20170038.1/1007A/R0/TA

Western Sydney Stadium - SoundPLAN Noise Emission Modelling

This letter presents the supplementary SoundPLAN noise emission modelling to address comments raised by the EPA in their letter dated 27 June 2017.

## APPENDIX ONE – SOUNDPLAN NOISE CONTOURS

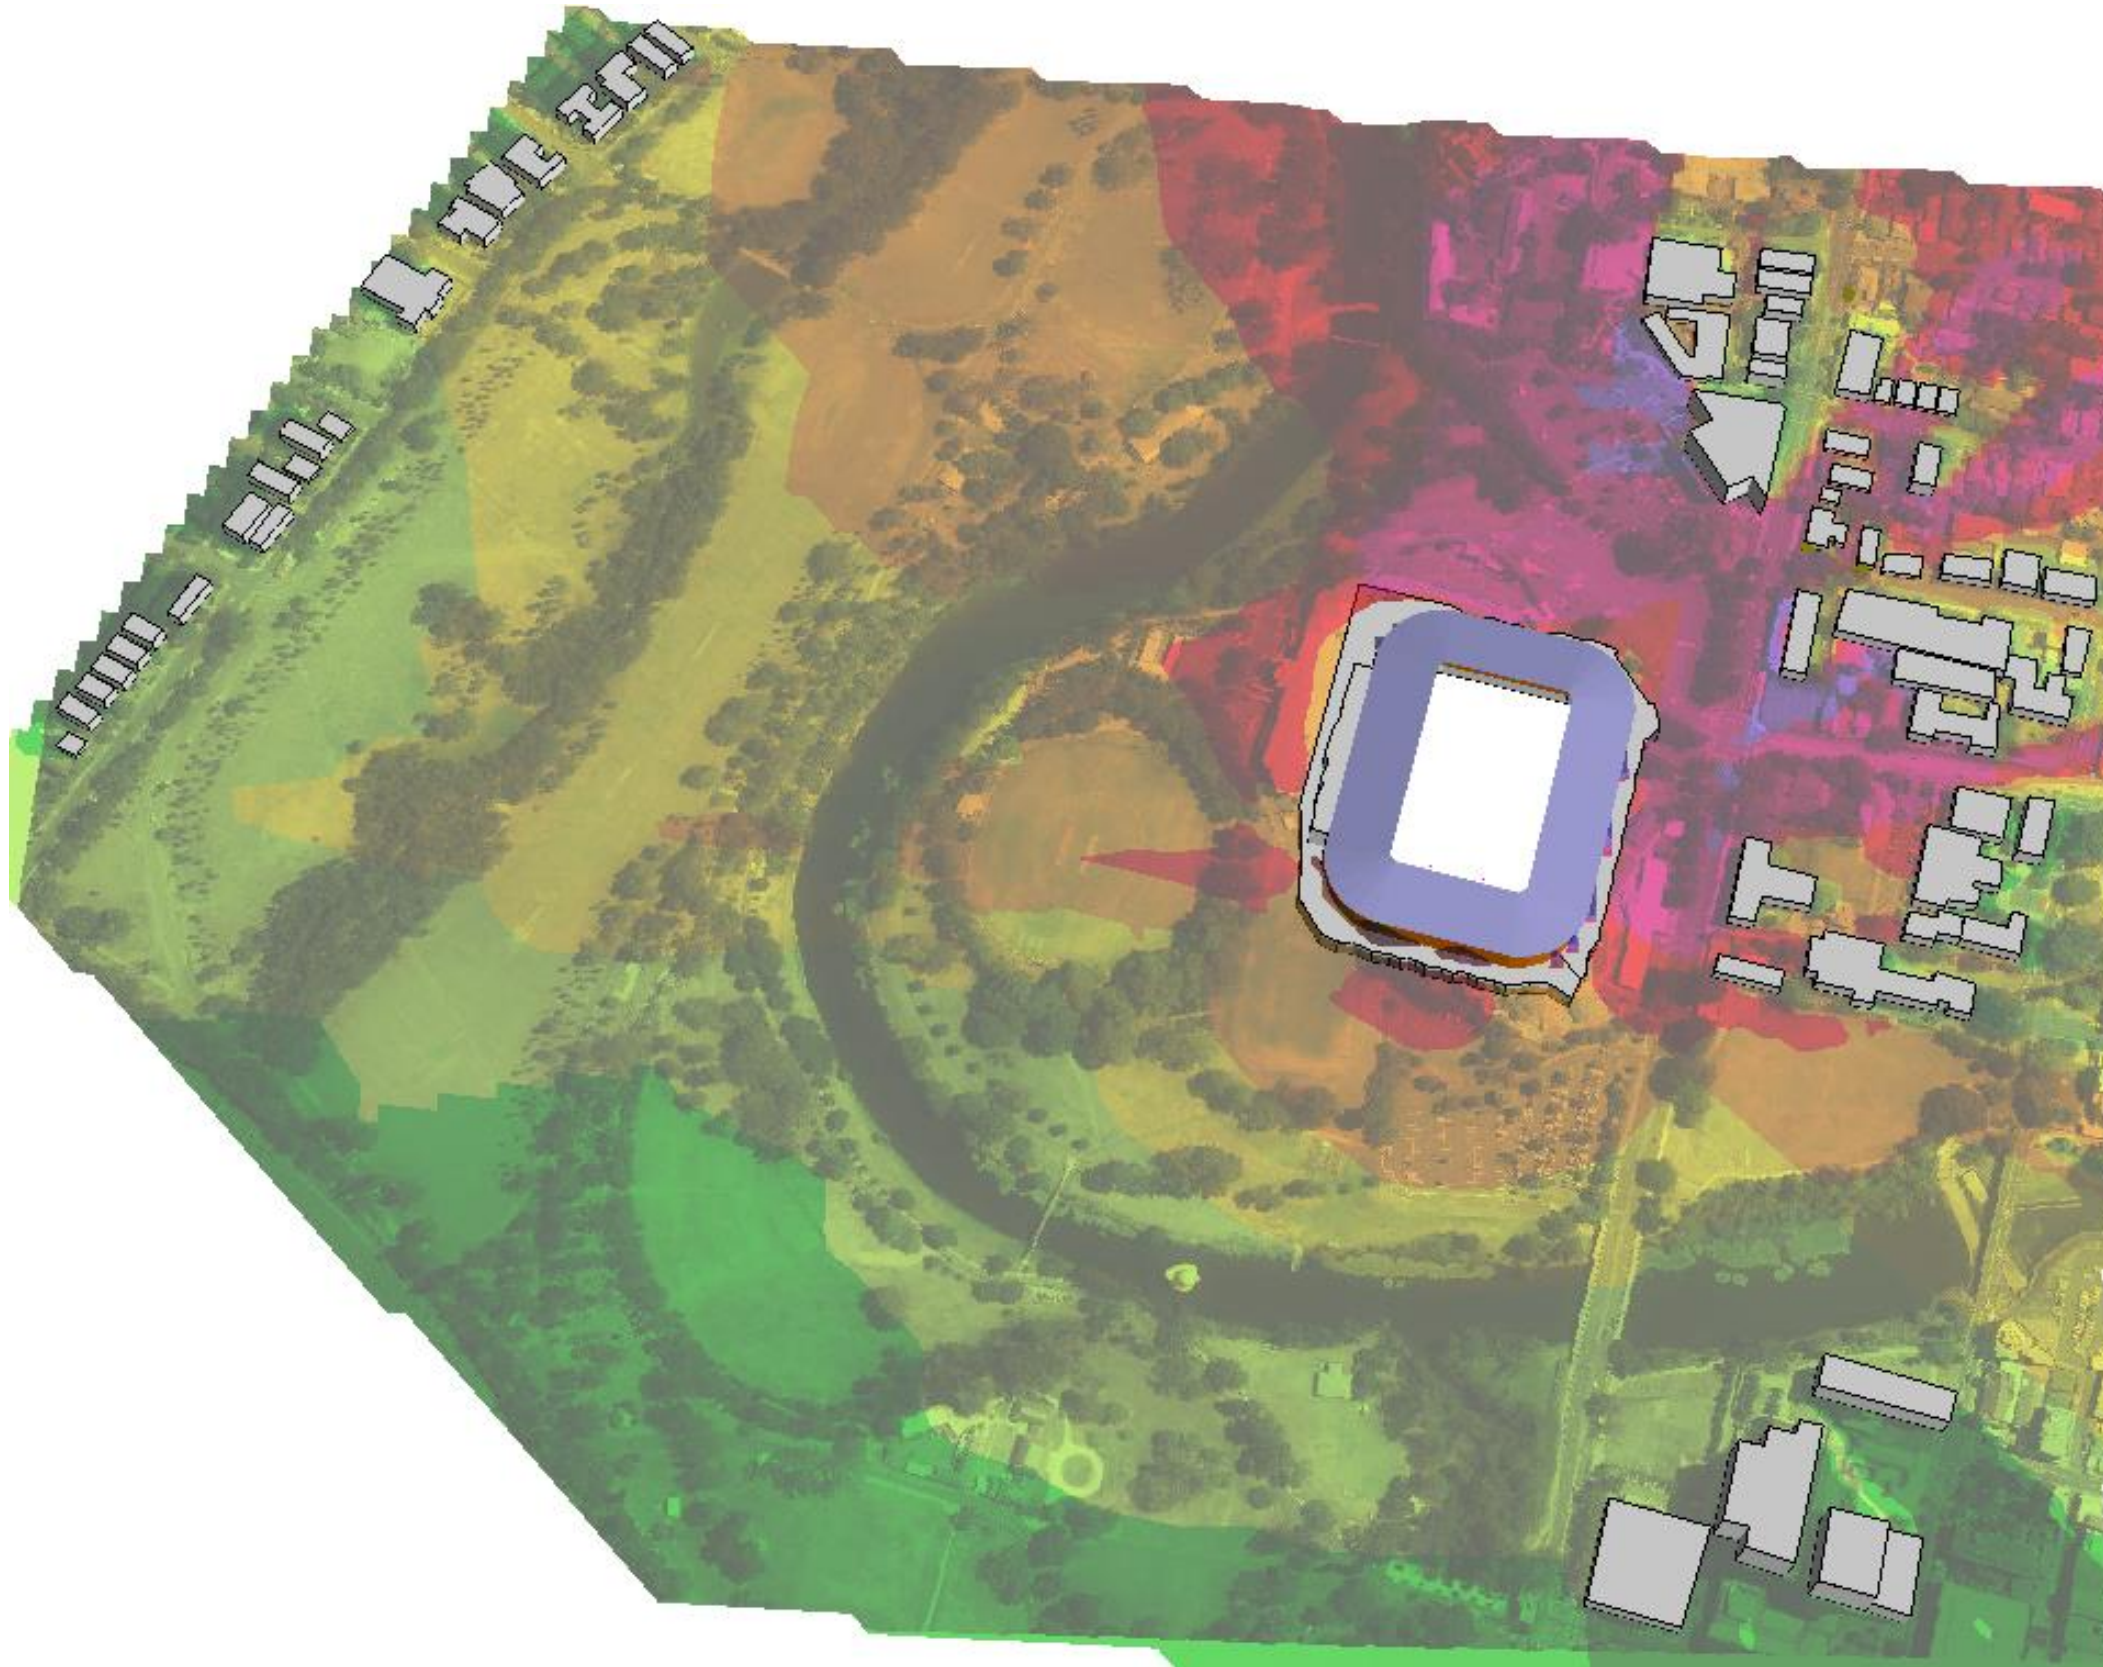
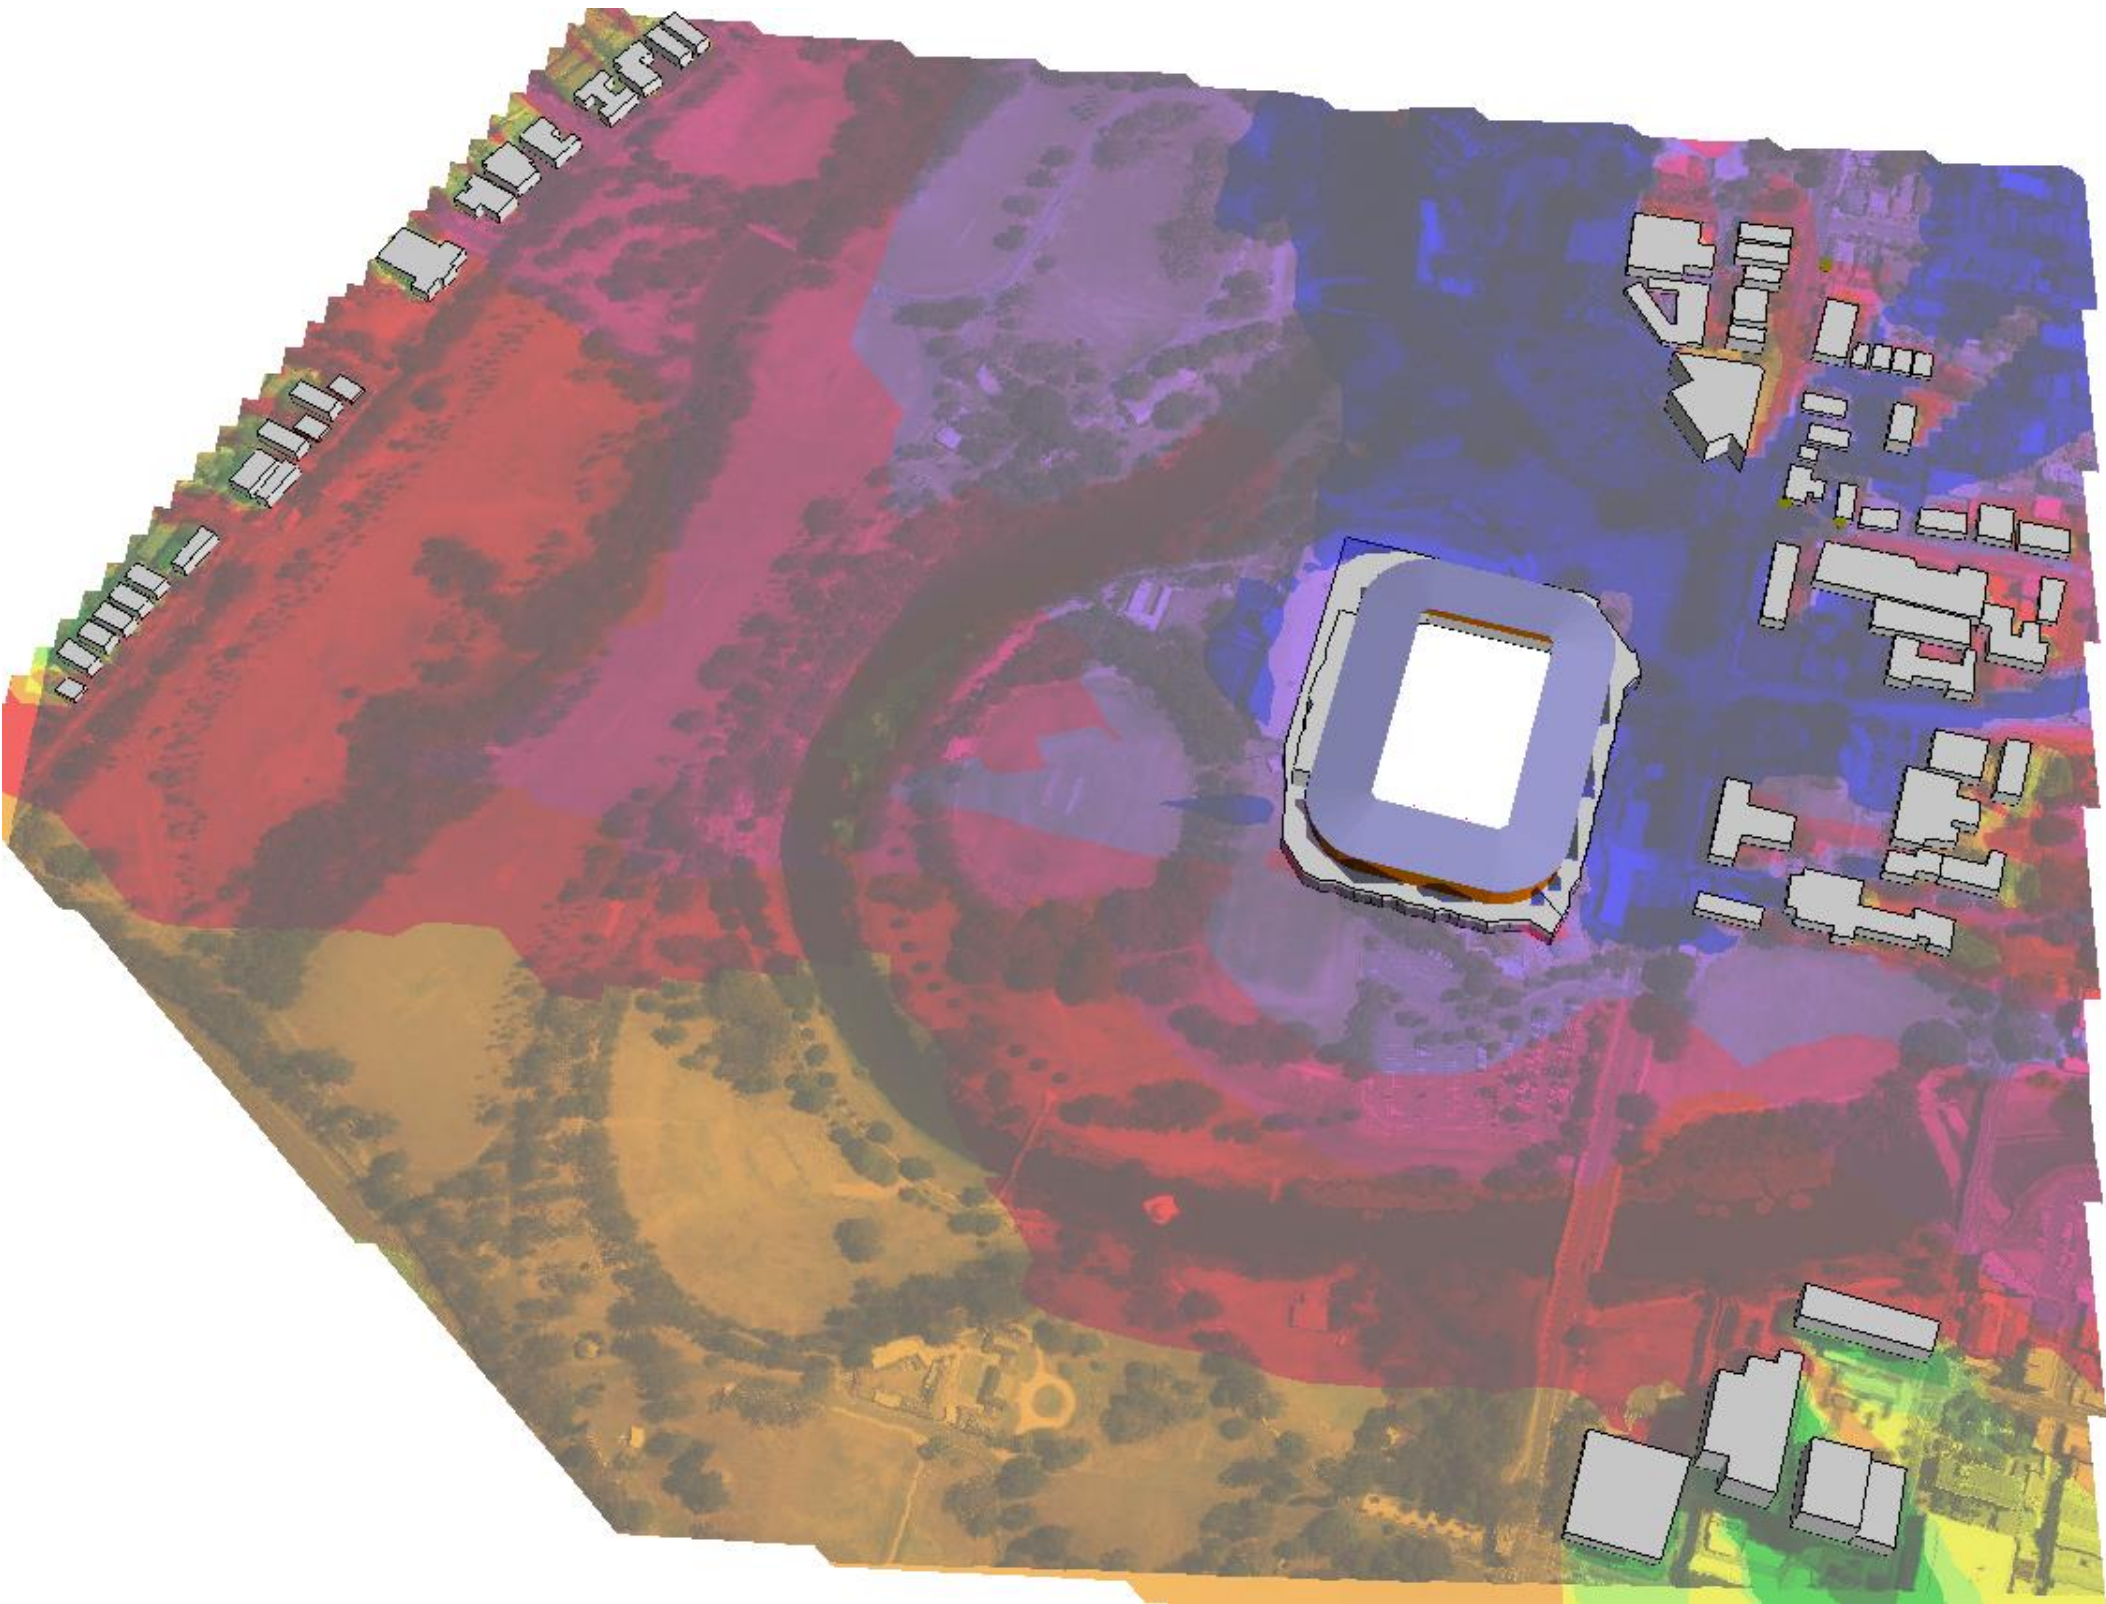
(a) provide a more detailed noise model of operational noise from the stadium, or other quantitative assessment, demonstrating that openings between seating tiers will not result in event noise being higher than predicted at sensitive receivers

The response to submissions did not demonstrate that all feasible and reasonable noise mitigation measures were included in modelling concert noise (for example, relocating the stage to face south, not north).

The openings between the seating tiers have been modelled and are presented as an isolated noise model in Appendix One. The predicted noise level contribution from the openings between the seating tiers is 64dB(A) at the nearest residential receivers in concert mode, 15dB(A) below the originally predicted noise level from the stadium as a whole, 78dB(A). As the contribution from the openings between the seating tiers is more than 10dB(A) below the predicted noise contribution of 78dB(A) from the main stadium, there is no increase in overall predicted noise level.

The stage has been relocated to the northern end (facing south). The results of this modelling are presented in Appendix Two. Modelling results indicate noise levels of 70dB(A) L_{eq} (including the contribution from the gaps between the seating tiers) for noise emissions during concert mode to receivers to the north. Previously these noise levels were predicted to be 78dB(A) L_{eq} with the Stage facing north.

The stage is now proposed to remain in this location, facing south, reducing noise emissions to the nearest residential receivers situated on O'Connell Street.
